# City of Albuquerque Stormwater Construction Site Inspection Report

ESC File No.	H10E033	Project Name:	2200 Vista Oriente
NPDES Id. No.	NMR10036M/NMR10060F	Location:	2200 Vista Oriente
11/8/2023	Owner	Contractor	
Operator	Tuan Huynh		
Contact name & title	Tuan Huynh		
e-mail	<a href="mailto:tuanvhn@gmail.com">tuanvhn@gmail.com</a>		
Contact Phone #	505-269-1418		
COA Inspector	Chancellor English	Start/End Time:	9am
Construction Phase:	none, weeds and partial land disturbance		
Type of Inspection:	<input checked="" type="checkbox"/> Regular	<input type="checkbox"/> Storm Event	<input type="checkbox"/> Post Storm Event >0.25" <input type="checkbox"/> 311/Complaint <input type="checkbox"/> Follow Up
Weather at time of inspection?	Clear	Temperature: ~	65
Estimated date of last storm 0.25" or greater	9/14/2023

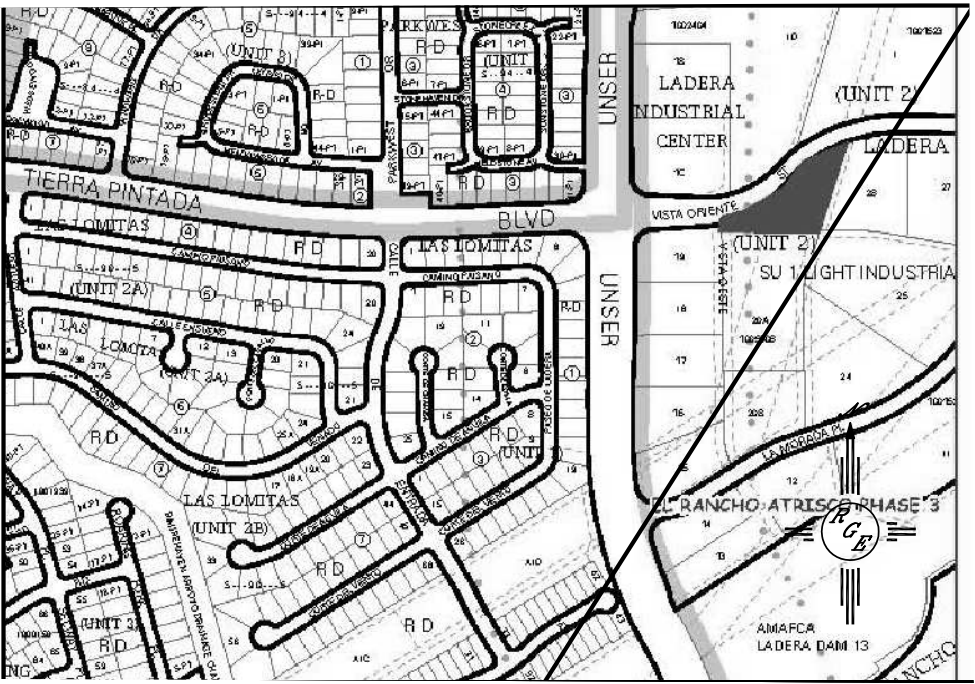
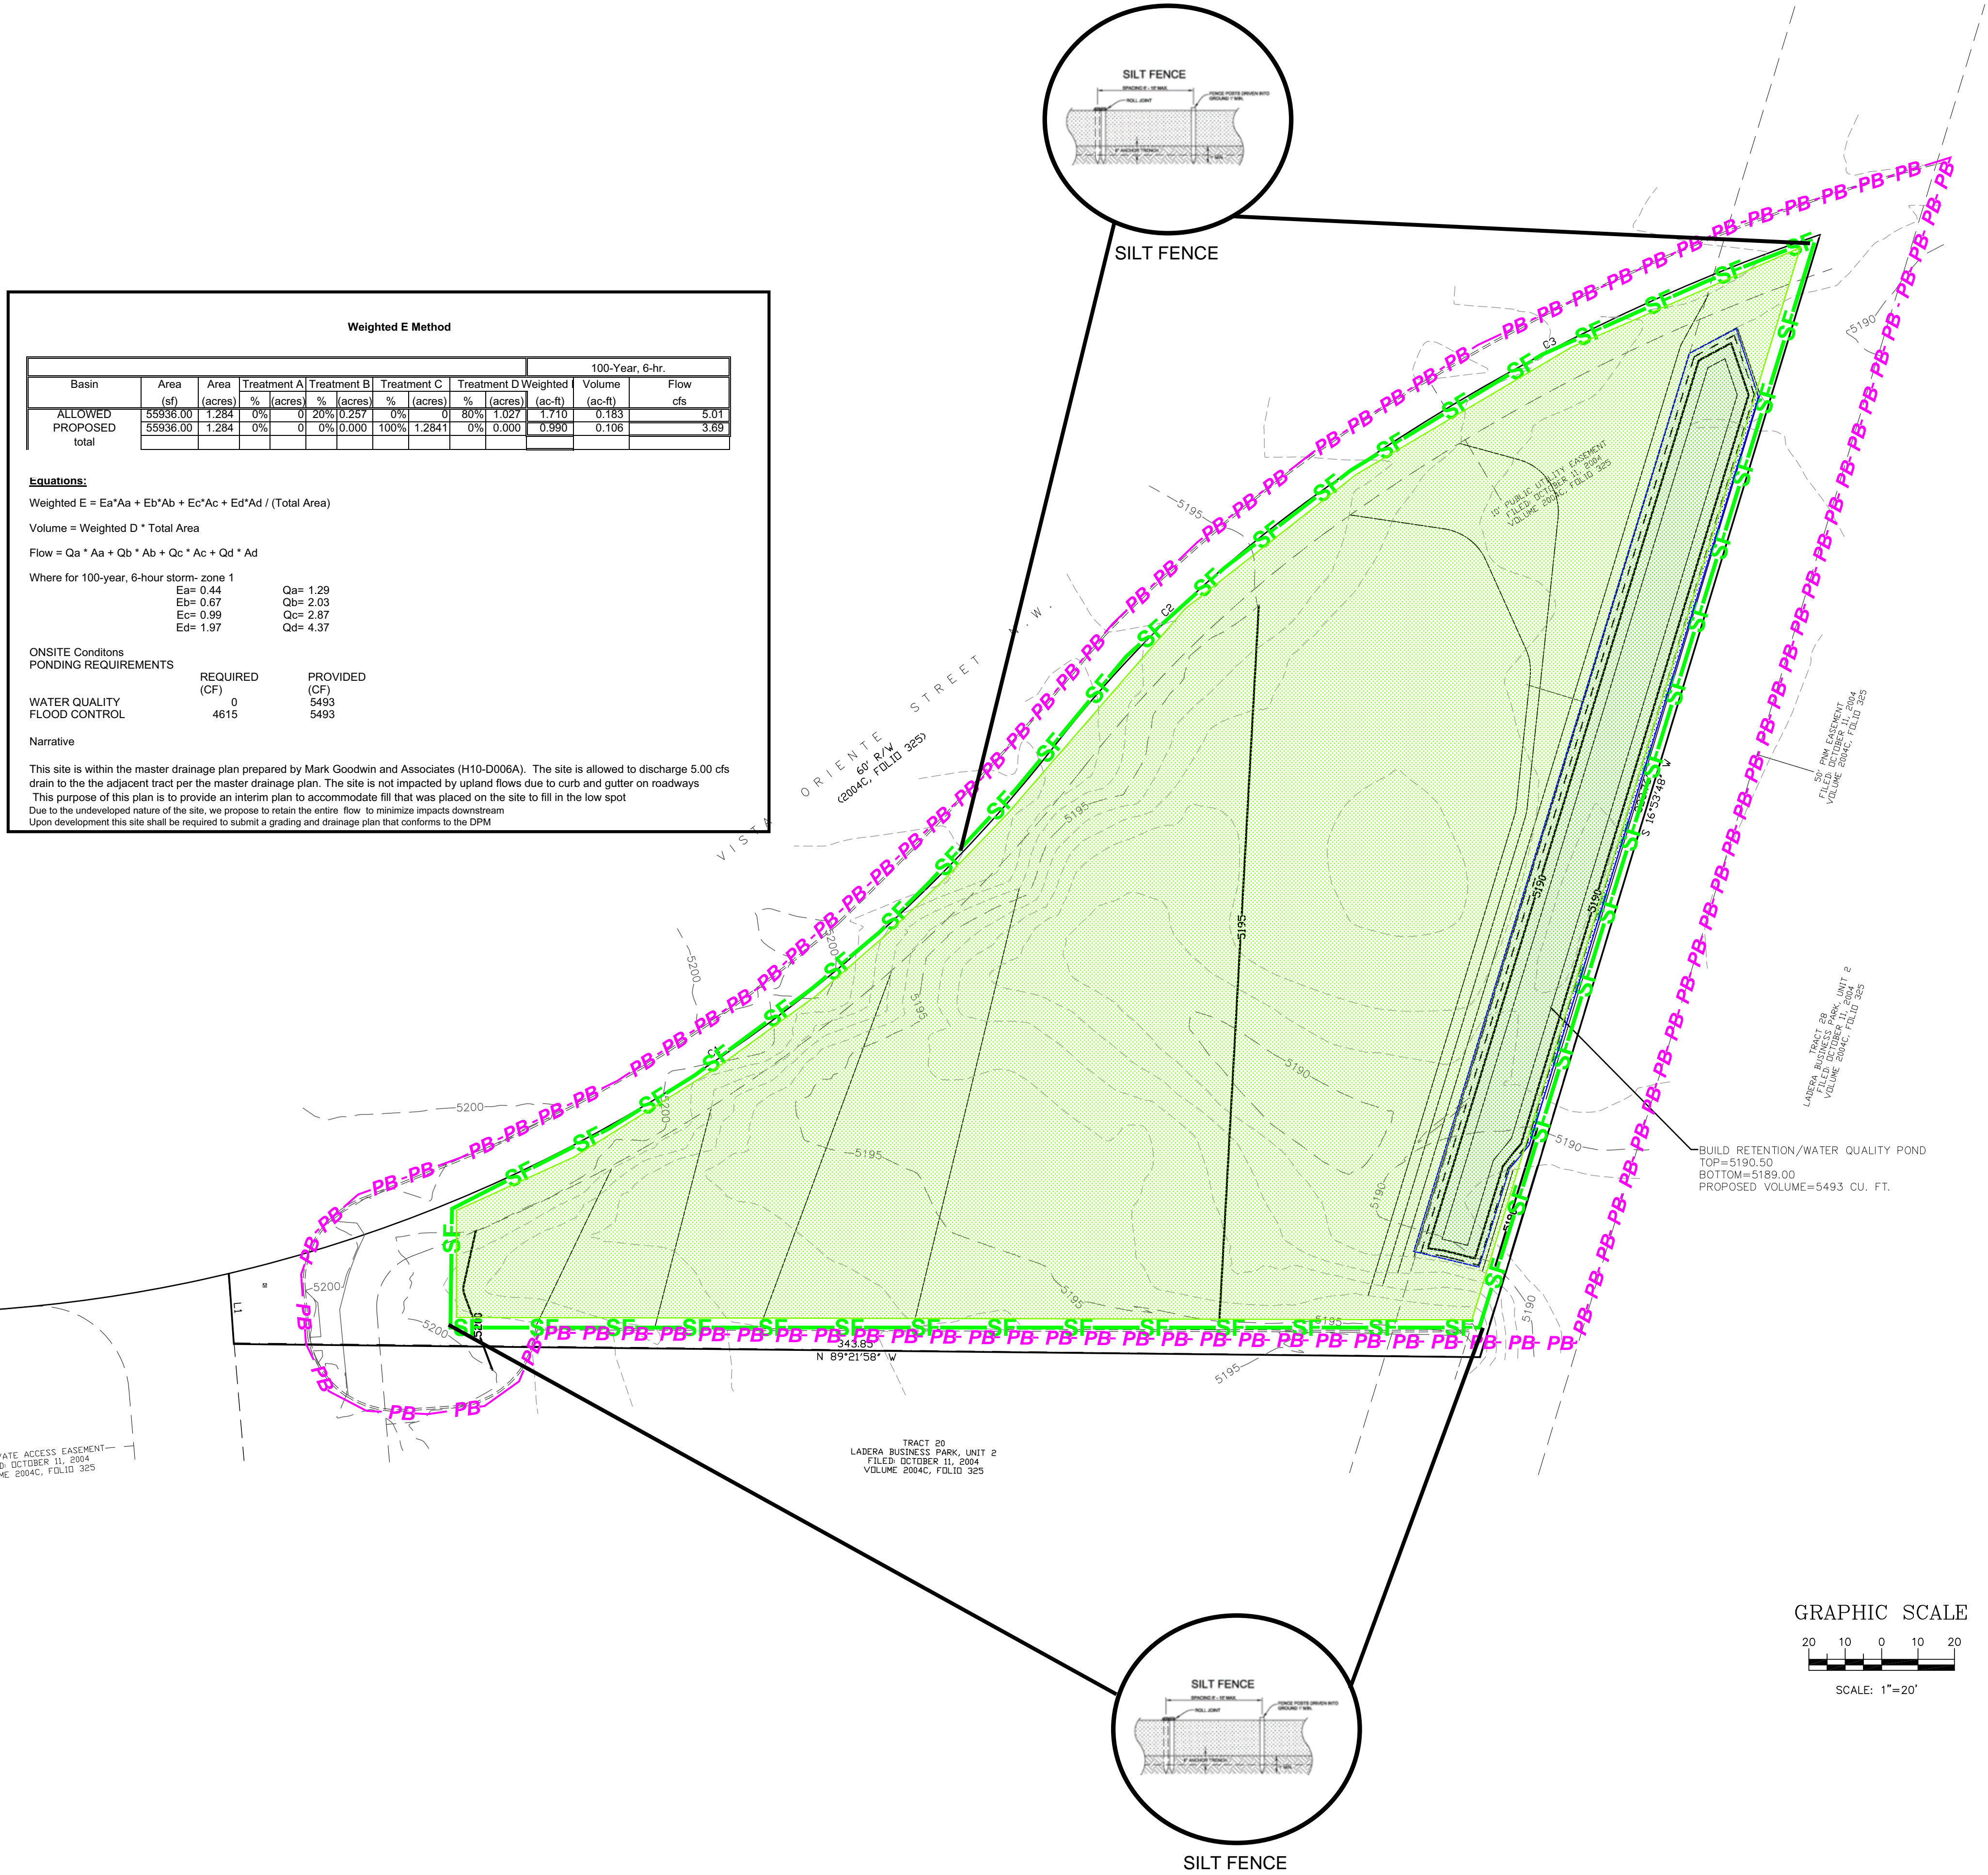
2	The site is still lacking compliant stabilization per CGP Part 2.2.14. The weeds are not sufficient vegetative cover and have become overgrown in violation of City Ordinance 9-8-4. The disturbed area needs stabilization. Required mitigation: Maintenance of weeds and stabilize the site if no construction activity for 14 or more calendar days as per CGP Part 2.2.14.

Notes:	Recent land disturbance on east side of site has been graded, but not stabilized
Prior violations for Posting, SWPPP, BMPs, and stabilization	
Weeds are becoming overgrown again and exceeding the 4" width and 4" height allowed by City Ordinance 9-8-4.
